Welwyn Hatfield Borough Council  
Planning Department  
Council Offices  
The Campus  
Welwyn Garden City  
AL8 6AE

**Ref: 6/2022/2801/MAJ**

Thank you for consulting us on the submitted planning application for Campus East Car Park, College Way, Welwyn Garden City, AL8 6DG. Demolition of all existing buildings and structures followed by the erection of five buildings to provide 313 residential units (Use Class C3); car and cycle parking, cycle and refuse storage, hard and soft landscaping, external lighting, drainage, infrastructure and all associated works.

Title
FLAT BLOCKS E & F
LEVELS 0, 1 & 2
PRIVATE + S/O GF (Block E)
AFFORDABLE RENT (Block F)

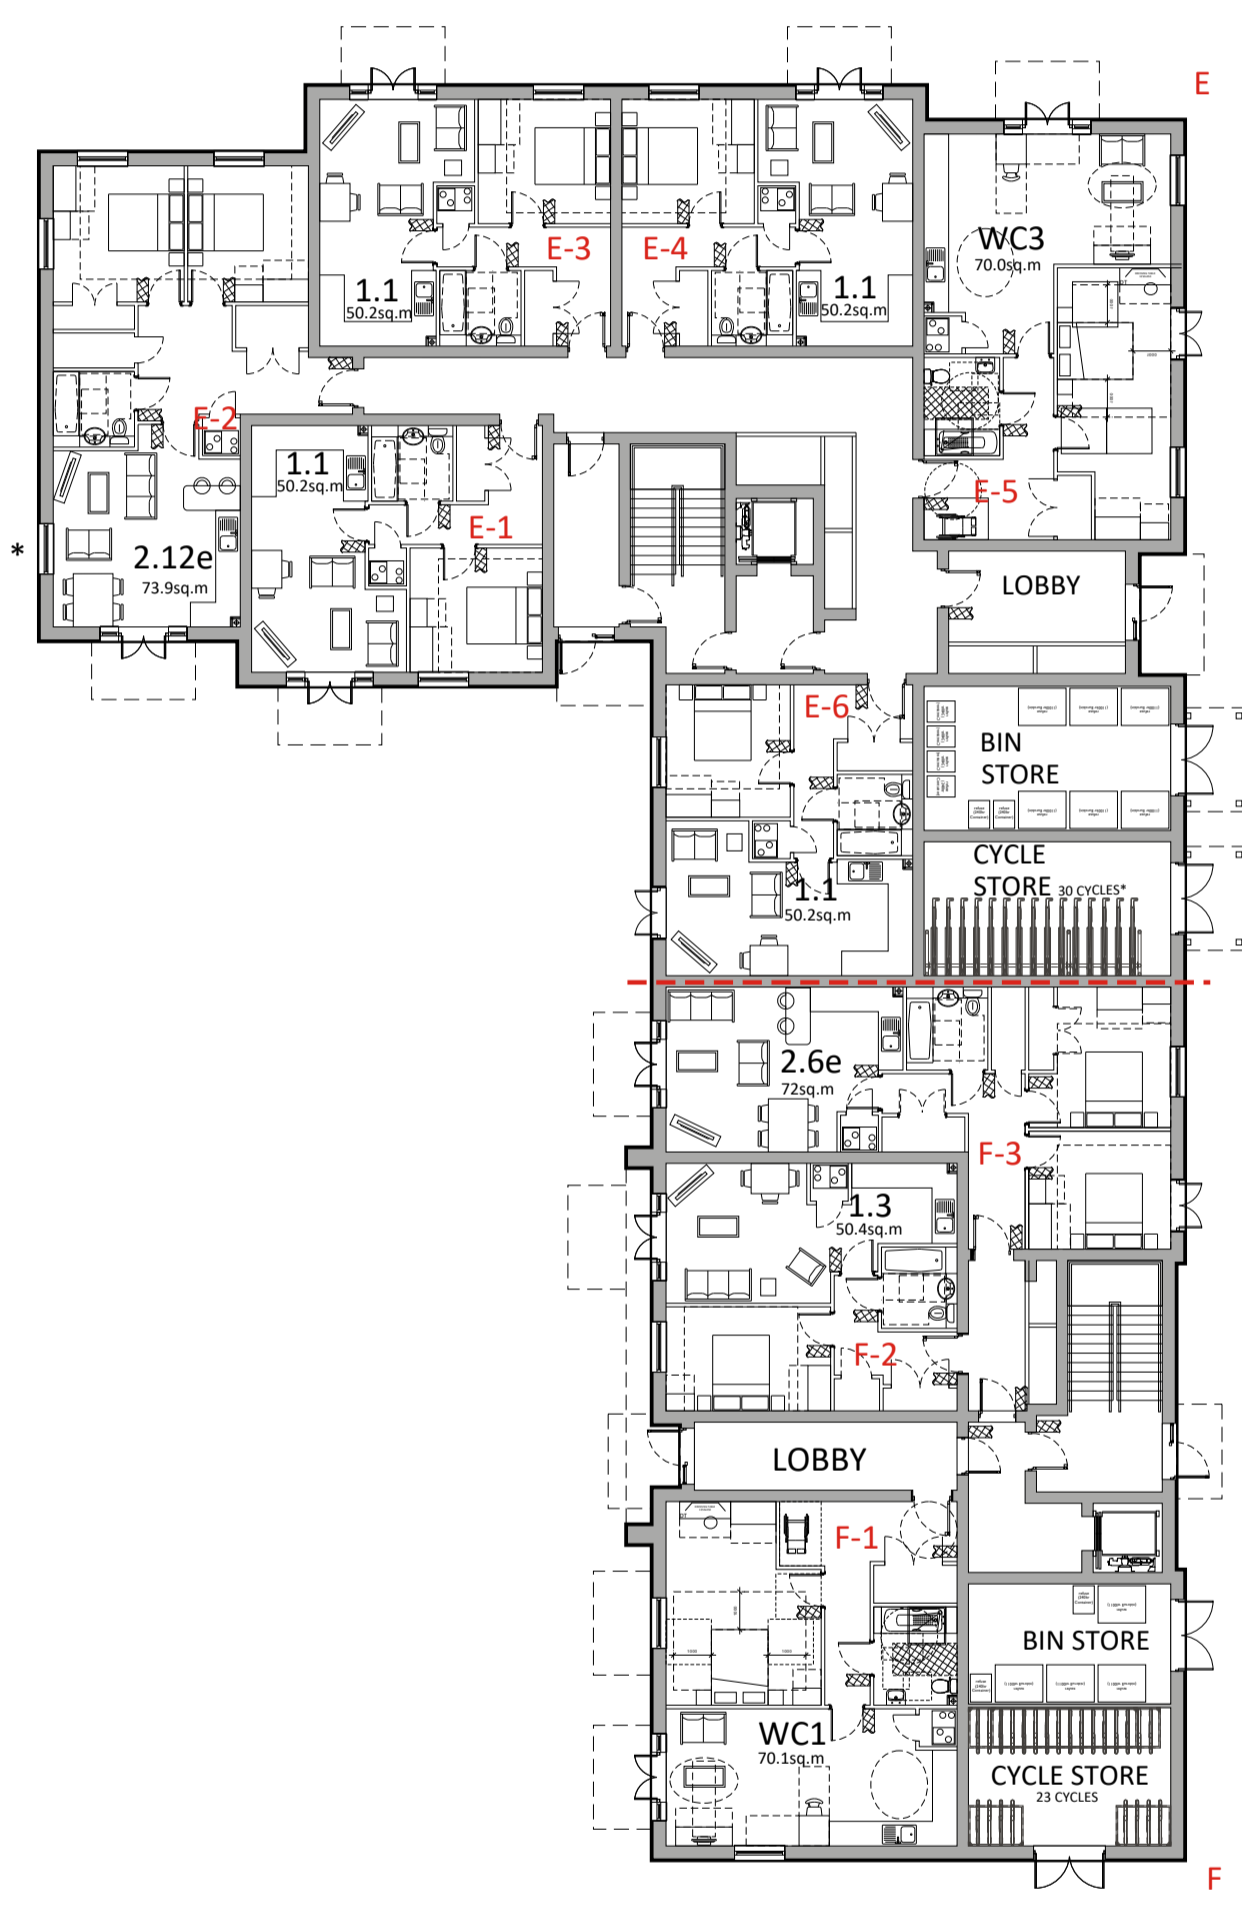
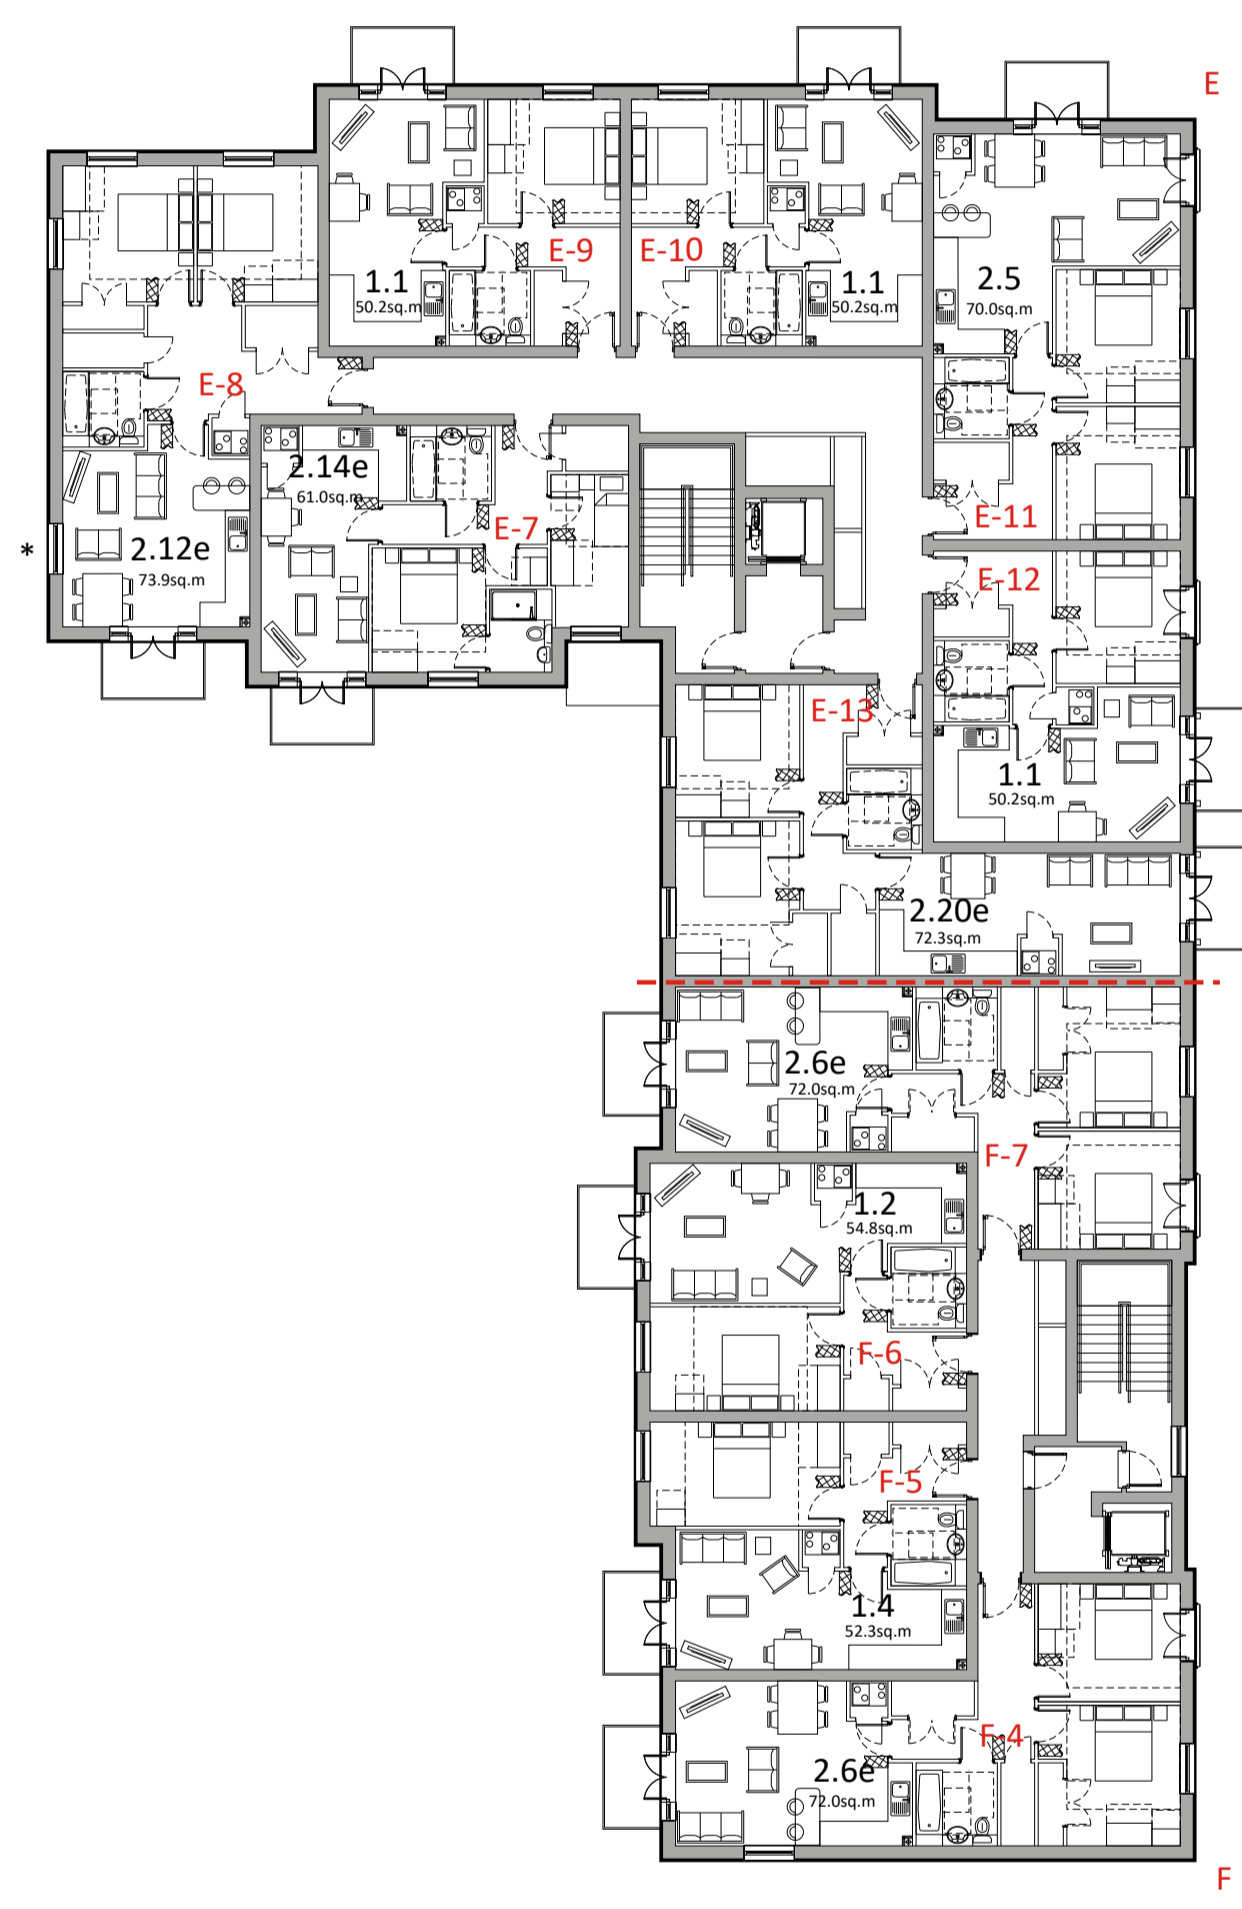
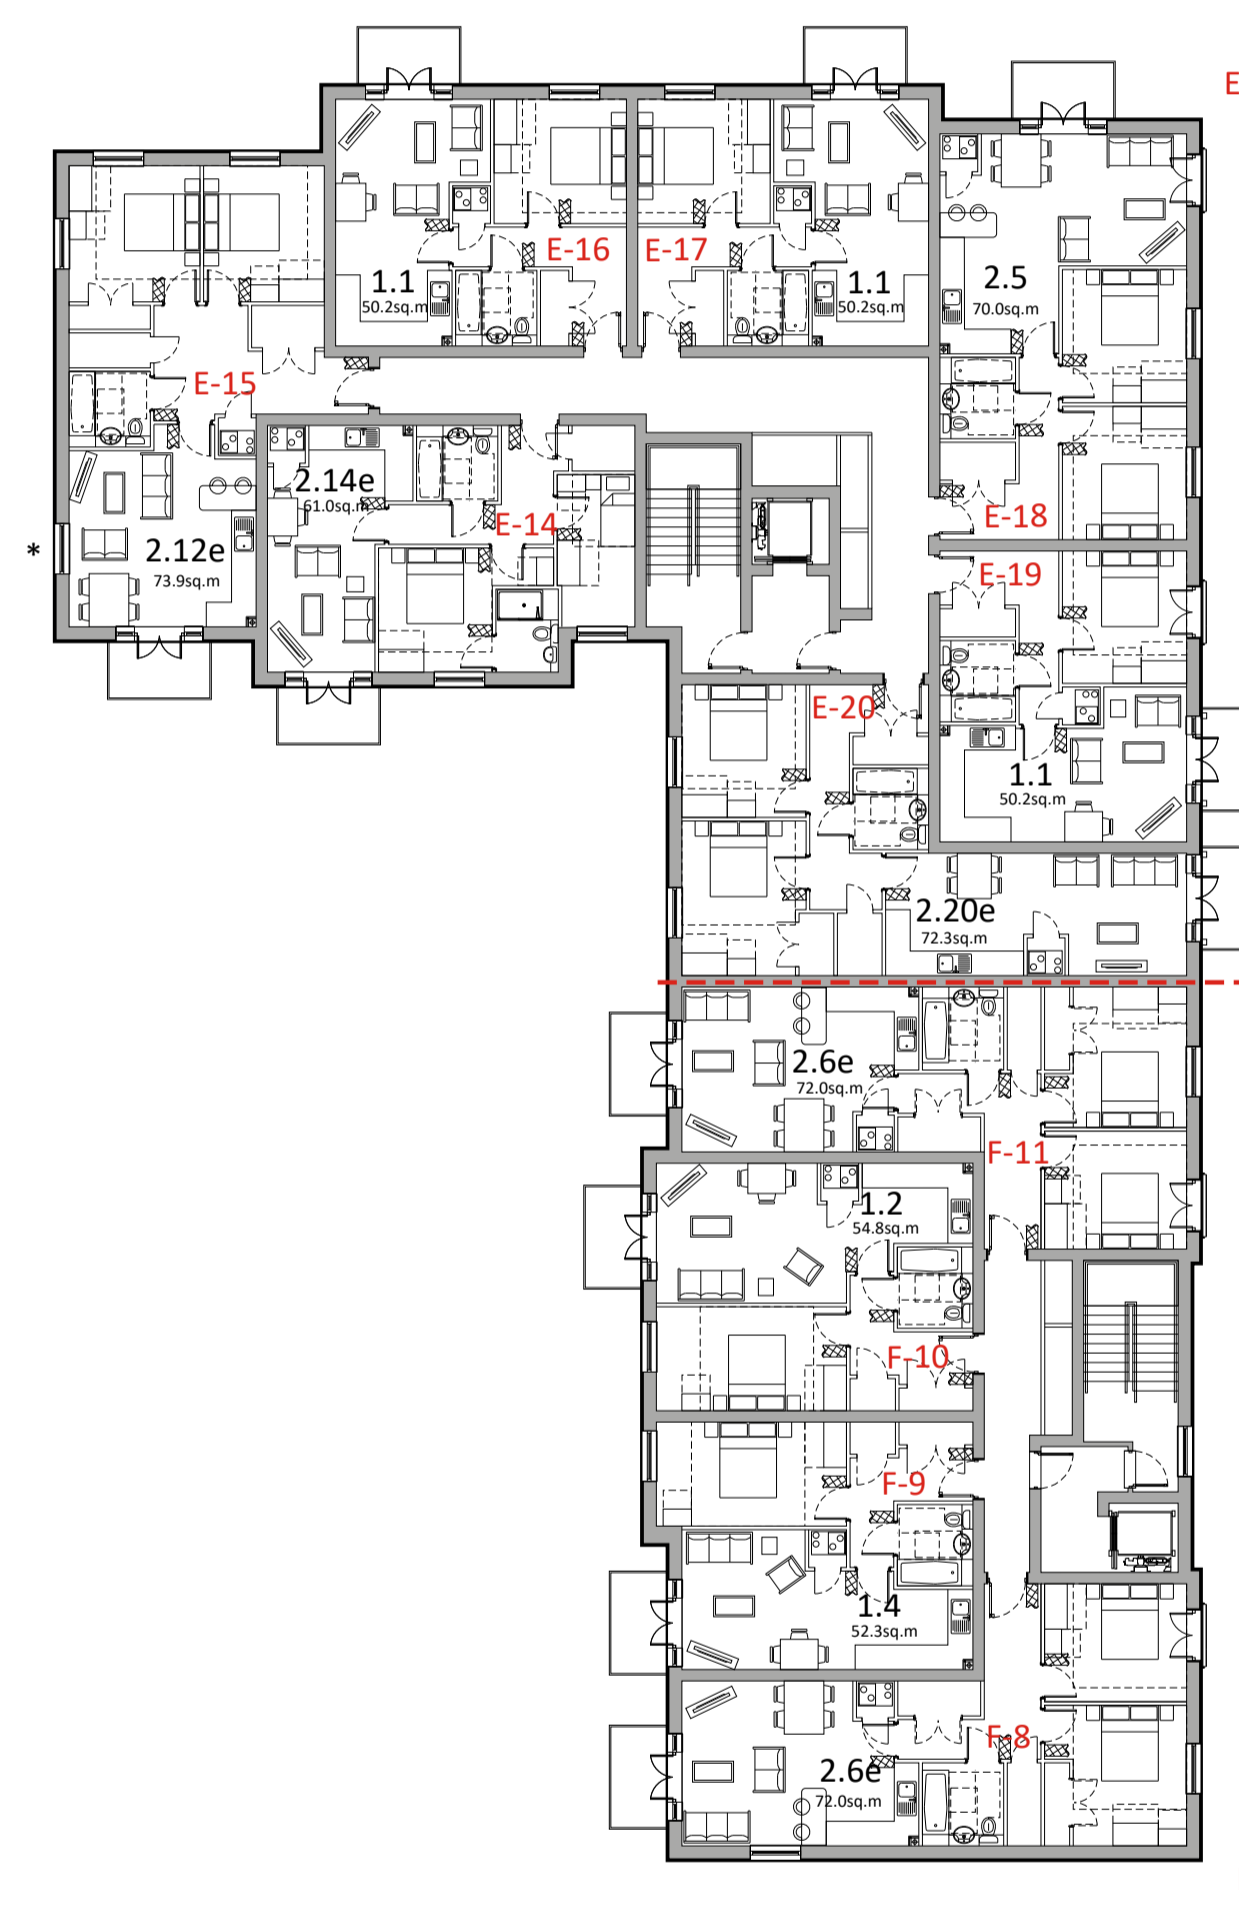
- End/flank elevation of Block E (overlooking the pedestrian access route) could also be improved to provide an improved public fronting end block,
- Materials and elevations generally need further refinement; some areas are over complicated (brick patterns/alignment) with various changes in brick and window surrounds. See DAS 7.3. The design approach should ideally seek to follow a simpler yet quality approach,

Some elevations (west facing Block E) could be improved to provide greater levels of passive surveillance onto the pedestrian route through the development. Details of the setbacks and boundary treatments to the ground floor apartments needs to be provided. For example, what are the security measures to provide setbacks, especially public fronting elevations.
